Job No: IAC-446

17 April 2016

**HEALTH INFRASTRUCTURE
LEVEL 6, 77 PACIFIC HIGHWAY
NORTH SYDNEY NSW 2060**REFERENCE: NSW FORENSIC PATHOLOGY AND CORONERS COURT
DOCUMENTATION REVIEW
ATTENTION: MR AARON SMITH

GROUND FLOOR PLAN
 NSW Forensic Pathology & Coroners Court

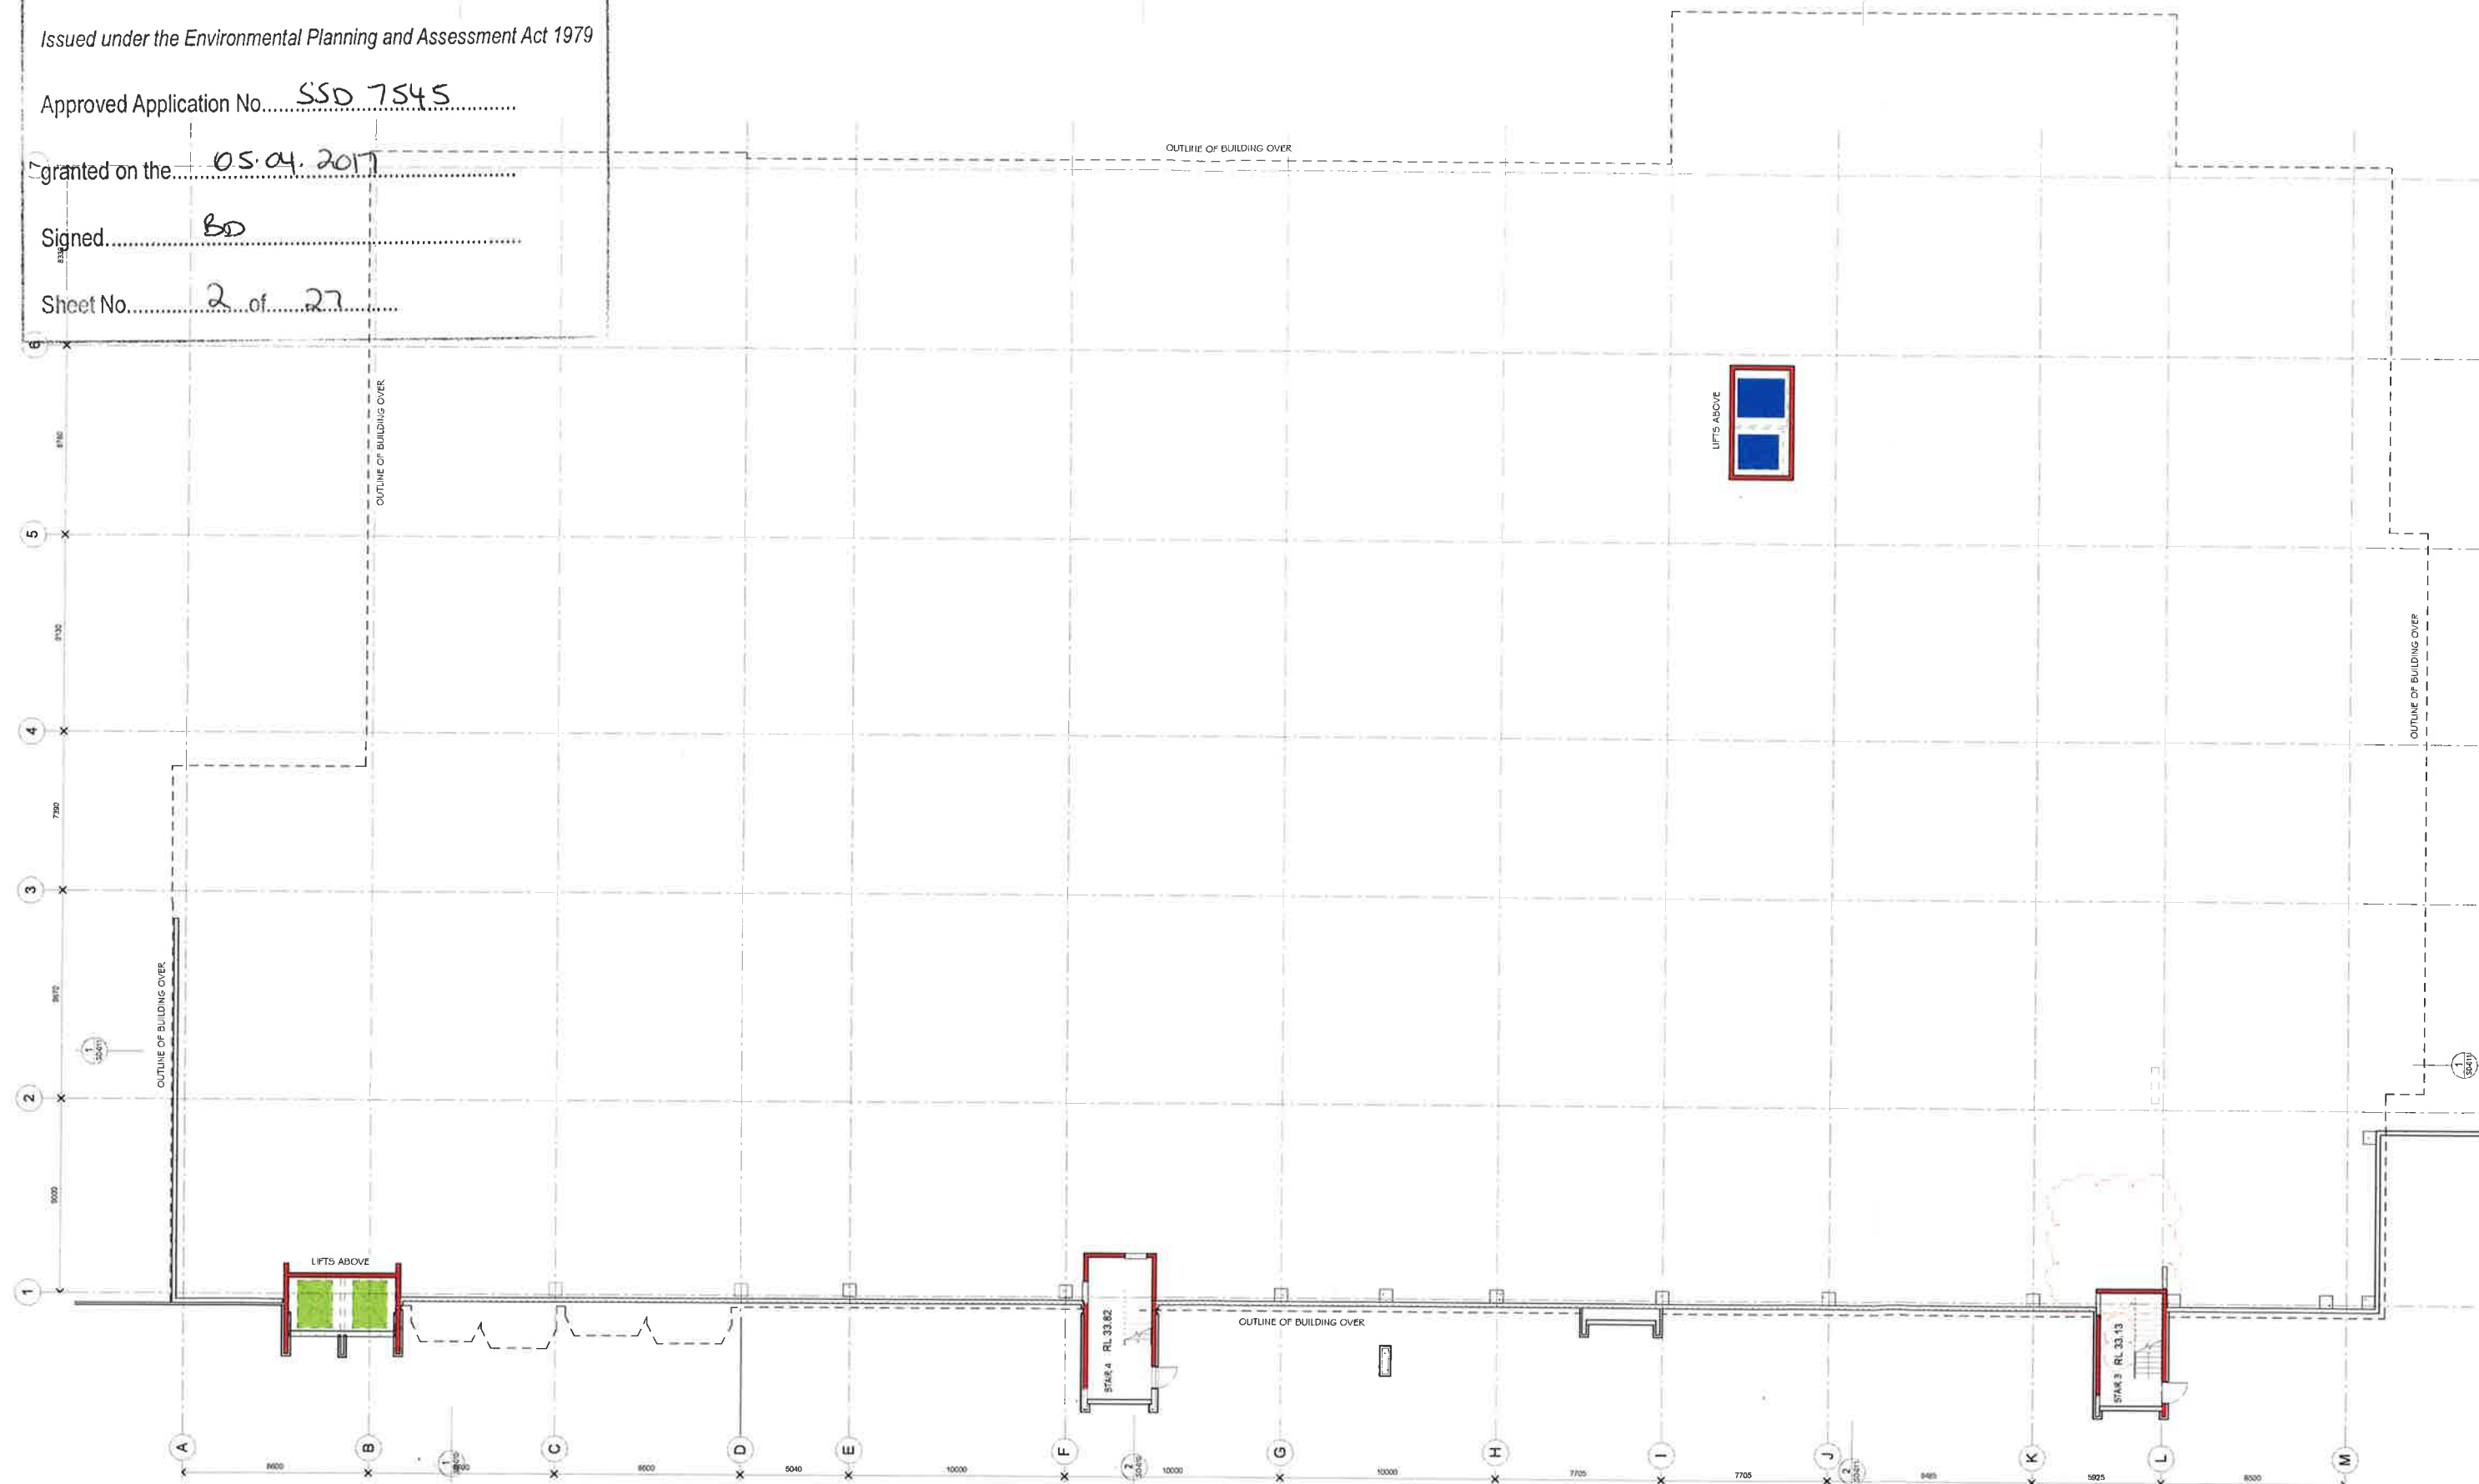
Documentation Review				
No	DWG No	Room	Discussion	Action
17.	SD-006		<p>There seem to be a problem with the extent of stairs associated with the Discrete Entry / Exit Point.</p> <p>RL35.98 is lower than the designated parking level therefore there will need to be a retaining wall in the landscape zone. This will need to be indicated on the plan.</p> <p>Accessible access will need to be provided from the carpark to the Discrete Entry / Exit Point. It is probable that an AS1735.7 Stairway platform lift will need to be installed.</p> <p>The extent of stairs will need to be reduced to create a connection between the bottom landing and the pathway around the building.</p> <p>The detailing of the stairs will need to satisfy clause 11 & 12 of AS1428.1:2009. Specific attention is directed to the following:</p> <ul style="list-style-type: none"> • Risers and going dimensions will satisfy the requirements of the NCC • The goings shall be non-slip and shall satisfy the requirements of NCC Table D2.14 and HB198 • Nosing shall be fixed to goings and nosing shall be non-slip • Handrails with compliant handrail extensions will need to be installed • Warning TGSIs will need to be installed at the top and bottom of the stair • Lighting of the stair compliant to the minimum lighting levels noted at Clause 19 of AS1428.2:1992 (150lx) 	<p>Ramp not indicated and has since been updated.</p> <p>Item to be developed under design development.</p>

18.	SD-006		<p>There are no RLs on the plan indicating the levels of the carpark in relation to the Coroners parking area and the direct connection to the building. This information will need to be provided.</p>	<p>RL 35.85 – level with the main ground floor.</p>

19.	SD-006	CAFÉ	<ol style="list-style-type: none"> 1. The detailing of the café will need to include a 1m wide path of travel 2. Seating areas will need to comply with the provisions of Clause 24 of AS1428.2:1992 3. The detailing of the service counter can adopt the side on approach of reach ranges (AS1428.2:1992) 4. There will need to be a low threshold detail at the door threshold to the external area 5. The installation of the paving materials of the external areas of the café will need to satisfy the provisions of Clause 7 of AS1428.1:2009 	<p>Noted. Item to be developed under design development. This may be a shall only space.</p>

20.	SD-006	Stair 1	<p>The detailing of Stair 1 will need to satisfy the provisions of Clauses 11 & 12 of AS1428.1:2009.</p> <p>The lighting level on the stair will need to satisfy Clause 19 of AS1428.2:1992 (150 lx)</p>	<p>Noted. Item to be developed under design development.</p>

21.	SD-006	Stair 2	<p>The detailing of Stair 2 will need to satisfy the provisions of Clauses 11 & 12 of AS1428.1:2009.</p> <p>The lighting level on the stair will need to satisfy Clause 19 of AS1428.2:1992 (150 lx)</p>	<p>Noted. Item to be developed under design development.</p>

Documentation Review				
No	DWG No	Room	Discussion	Action
22.	SD-006	Stair 3 & 4	It is assumed that Stairs 3 & 4 are fire stairs and not circulation stairs. The detailing of Stair 3 will need to satisfy the provisions of the NCC and NCC Clause D3.3(a)(iii) which reference the requirements of Clause 11.1 (f) & (g) of AS1428.1:2009	Stairs are fire escapes. Other items to be developed under design development.

23.	SD-006	All stairs	The detailing of the stairs within in this facility will need to be detailed to ensure that there are no vertical sections in the detailing of the handrails (Clause 11.2(c) AS1428.1:2009) Warning TGSIs will need to be installed at the top and bottom of each stair flight. TGSIs are not required at mid-landings. TGSIs are not required for Stairs 3 & 4.	Noted. Item to be developed under design development.

24.	SD-006	Seating area	The profiles of the furniture located in the waiting area will need to satisfy the furniture dimensions noted at Clause 27 of AS1428.2:1992. (Refer attached sheet)	Noted. Item to be developed under design development.

25.	SD-006	Lifts (Grid B1)	The detailing of the lift cars will need to satisfy the requirements of AS1735.12. The minimum lift car size will need to be 1100 x 1400mm as the travel distance is less than 12m. The actual size of the lift cars will need to be determined by the Vertical Transport consultant.	Noted. Item to be developed under design development.

26.	SD-006	Reception	The detailing of the reception counter will need to satisfy the requirements of Clause 24 of AS1428.2:1992 with the provision of a wheelchair zone. If the counter is fully enclosed, then a hearing augmentation system compliant to the provisions of NCC Clause D3.7 will need to be installed. The detailing of the furniture in relation to the doors to the reception area will need to be revised so that the required circulation at doorways requirements of Clause 13 of AS1428.1:2009 can be satisfied.	Noted. Item to be developed under design development.

27.	SD-006	Accessible WC	The detailing of the accessible WC located Within the Reception Zone will need to satisfy the provisions of Clause 15 of AS1428.1:2009. Refer to attached checklist.	Noted. Item to be developed under design development.

28.	SD-006	Turning Area	The minimum width of the corridor to the Teaching Viewing Suite will need to be 1540mm to allow for a wheelchair user to make a 180deg turn. The space required is 1540 x 2070mm.	150mm is achieved.

29.	SD-006	Teaching viewing suite	The paths of travel to the Teaching viewing suite will need to be increased to satisfy the Circulation provisions of AS1428.1:2009. The areas requiring review include: <ul style="list-style-type: none"> • Circulation at the entry door • 1500 x 1500mm 90deg turn along path of travel • Provision of a wheelchair seating zone to satisfy Clause 18 of AS1428.1:2009 	Noted. Item to be developed under design development.

Documentation Review				
No	DWG No	Room	Discussion	Action
30.	SD-006	WC Public Facilities	These facilities will need to include for an ambulant cubicle located within each bank of WC facilities. The detailing of the ambulant facilities will need to satisfy the provisions of Clause 16 of AS1428.1:2009.	Noted. Item to be developed under design development.

31.	SD-006	Courtyard - relatives	Accessible access will be required to each of the courtyards. Details as to threshold detail, pavement materials etc will need to be provided.	Noted. Item to be developed under design development.

32.	SD-006	Change rooms	There are no accessible change room facilities proposed within this facility?	Accessible change room facilities included on level one. Further facilities to be incorporated in detail design to the ground floor facilities.

33.	SD-006	Change rooms	The width of the corridor to the doors of the change rooms will need to be increased to satisfy the provisions of Clause 13 of AS1428.1:2009.	Noted. Item to be developed under design development.

34.	SD-006	Change rooms	The space requirements at the dead end of the corridor to the change rooms will need to be increased to provide a 180deg turning zone (1540 x 2070mm)	Noted. Item to be developed under design development.

35.	SD-006	Change Room	Ambulant WC Facilities have been provided within each change room. An accessible shower will need to be provided within each change room to satisfy the provisions of NCC Table F2.4(b) which requires accessible showers to be provided at the rate of 1:10 showers.	Noted. Item to be developed under design development.

36.	SD-006	Doors Generally	All doors to accessible rooms will need to have a minimum clear width of 850mm and will need to satisfy the provisions of Clause 13 of AS1428.1:2990. Where double doors are installed the minimum clear width of the active leaf will need to be 850mm. The force required to operate doors (other than fire doors) fitted with door closers will need to be 20N The placement of vision panels in doors will need to satisfy the provisions of Clause 11.6.2 of AS1428.2:1992 (refer to attached Technical Sheet)	Doors are show at 970mm. Other items to be developed under design development.
